West Oxfordshire District Council

Response to Botley West Solar Farm Statutory Consultation

February 2024

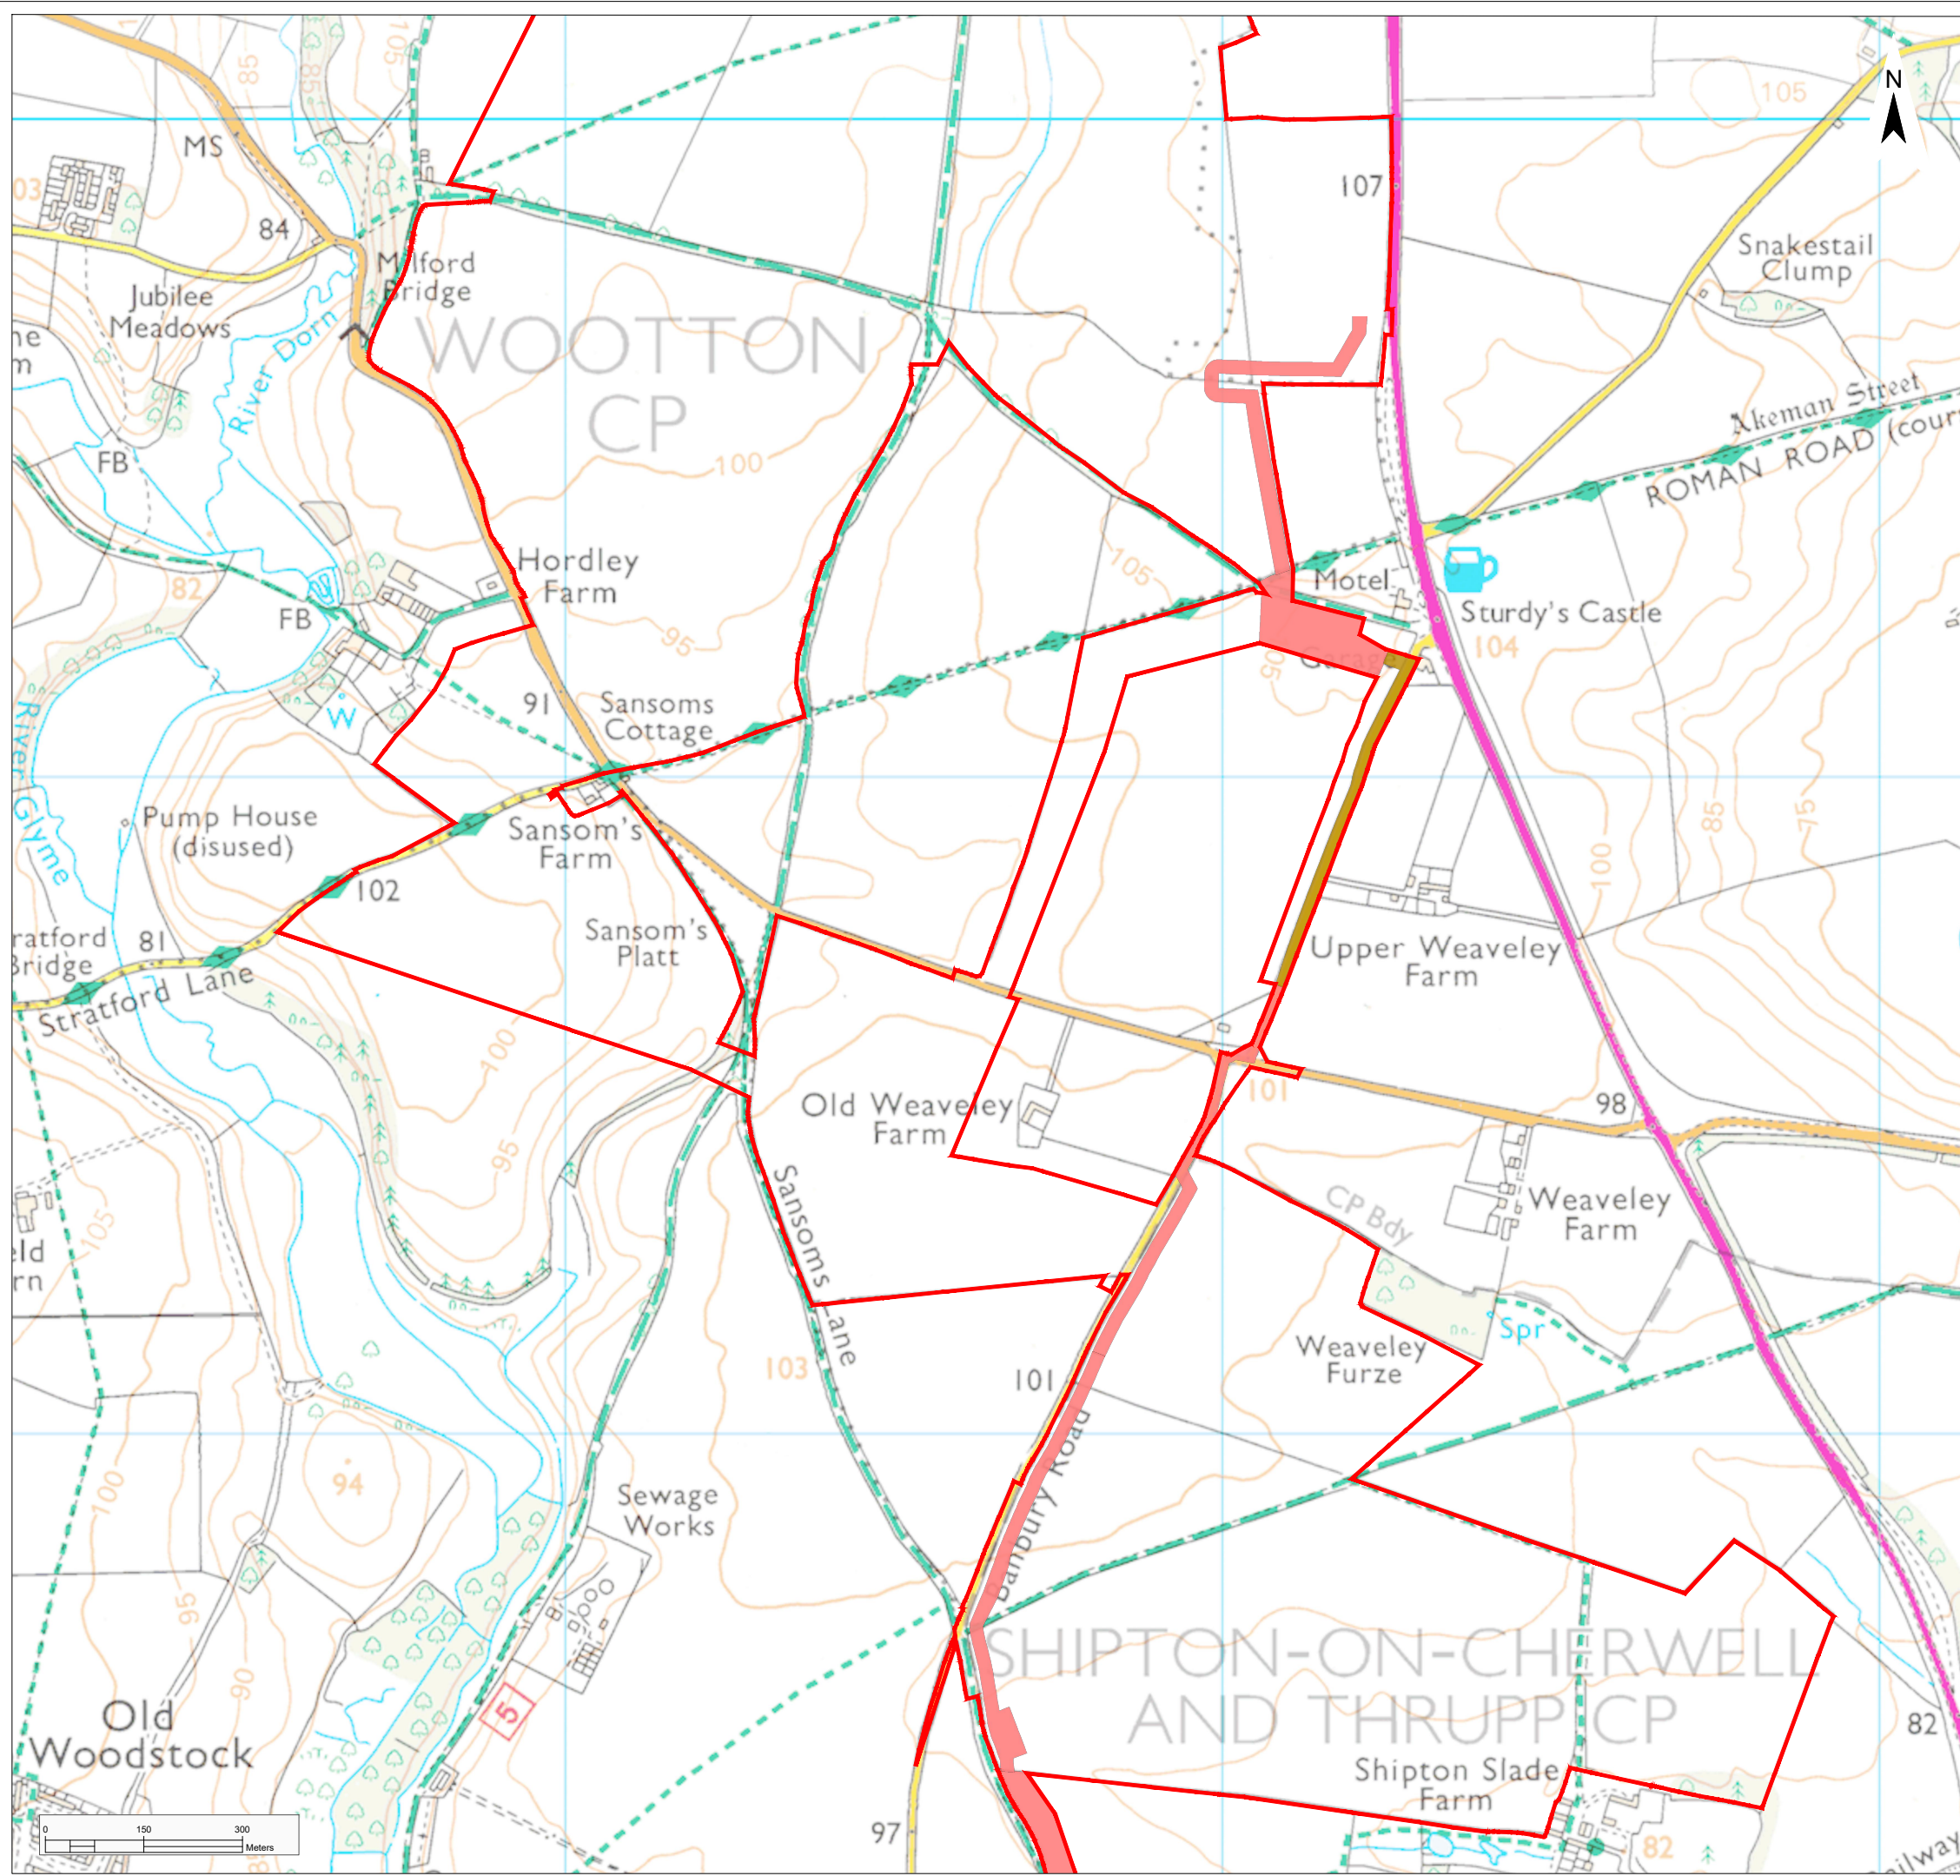
- 4.8 **The masterplan for the northern area shows an extensive and relatively dense configuration of solar panels occupying elevated land between the settlements of Wootton to the west, Tackley to the east and Woodstock to the south west.**

- 4.10 **Significant to the baseline assessment of the northern area are the presence of historical features within and in close proximity to the site, particularly the presence of a Scheduled Monument adjacent to Sansom's Cottages which the northern development area largely encloses.**

- 4.11 **There is an extensive public right of way (PRoW) network within and around this Northern Site, most prominently the Oxfordshire Way, which crosses the Site on an east-west bearing. The 416/11/20 bridleway also runs in a north-south bearing through the Site for almost its entire length.**

- 4.12 **Although development is excluded from the Scheduled Monument and mitigation measures have been proposed to accommodate development in areas of archaeological interest, additional buffering in areas affecting the setting of the Scheduled Monument, Listed Buildings and Akeman Street may be beneficial. Land slopes down to the south from bridleway 416/21/10 east of Milford Bridge to Akeman Street making the landscape more prominent and open in this location. Limiting development in this area could further reduce the magnitude and significance of impacts against a range of sensitive receptors in this location.**

- 4.14 **It is noted that there are residential properties in close proximity to the project area in the Northern Site. Serious consideration should be given as to whether a minimum buffer distance between development and residential properties would be appropriate to minimise impacts on residents.**
